Re: CAO22-17 (Houtchens Critical Area Review
Request for Information #1
6024 SE 22nd St.

The following is in response to your Critical Area Review 2 dated January 23, 2023.

SHEET TITLE: STRUCTURAL DETAILS
 DATE: 4-18-22
 SHEET NO.

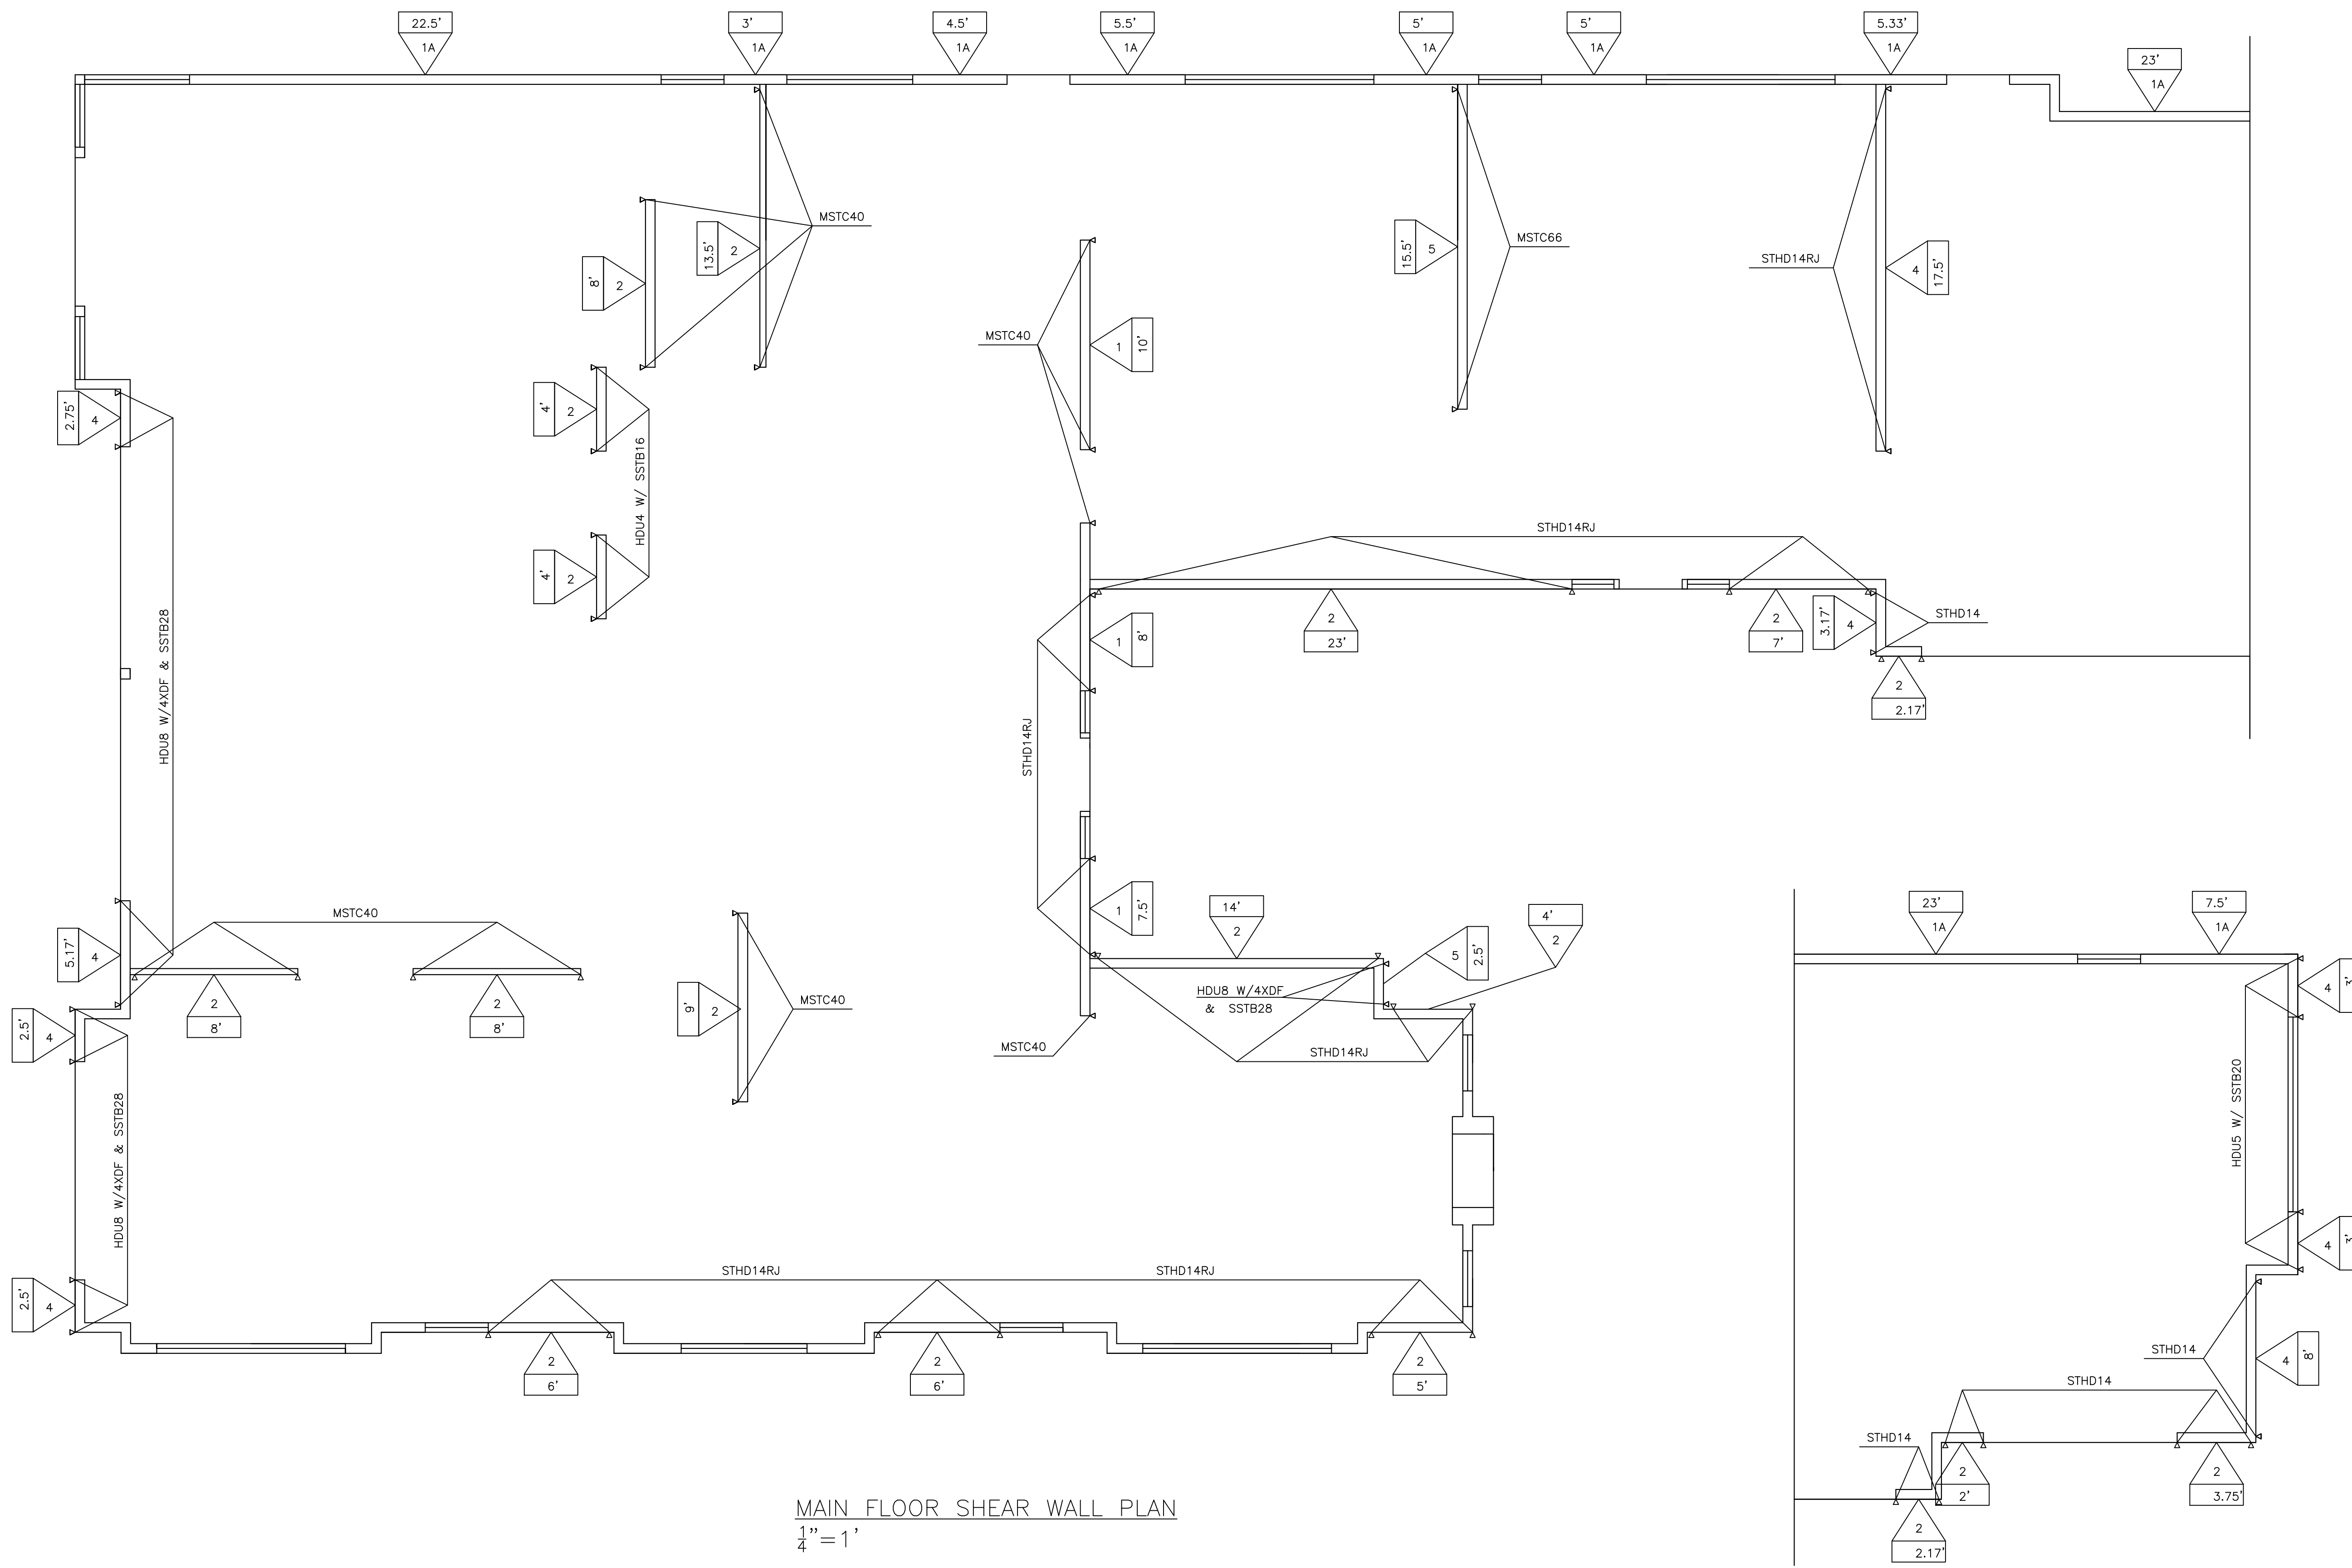
1. See attached Landscape Plan on sheets L1, L2 & L3.
2. See attached statement of risk from Geotechnical Engineer.
3. From Structural Engineer:
Yes, it is slab on grade construction and not a structural slab. The information was added to the structural notes on S1 and all details showing slab on grade on S2 and S3.
Note is also on sheets P1, P2, A1 & A2.
4. From Structural Engineer:
This information was added to the structural notes on S1.
5. From Structural Engineer:
This information was added to the structural notes on S1.
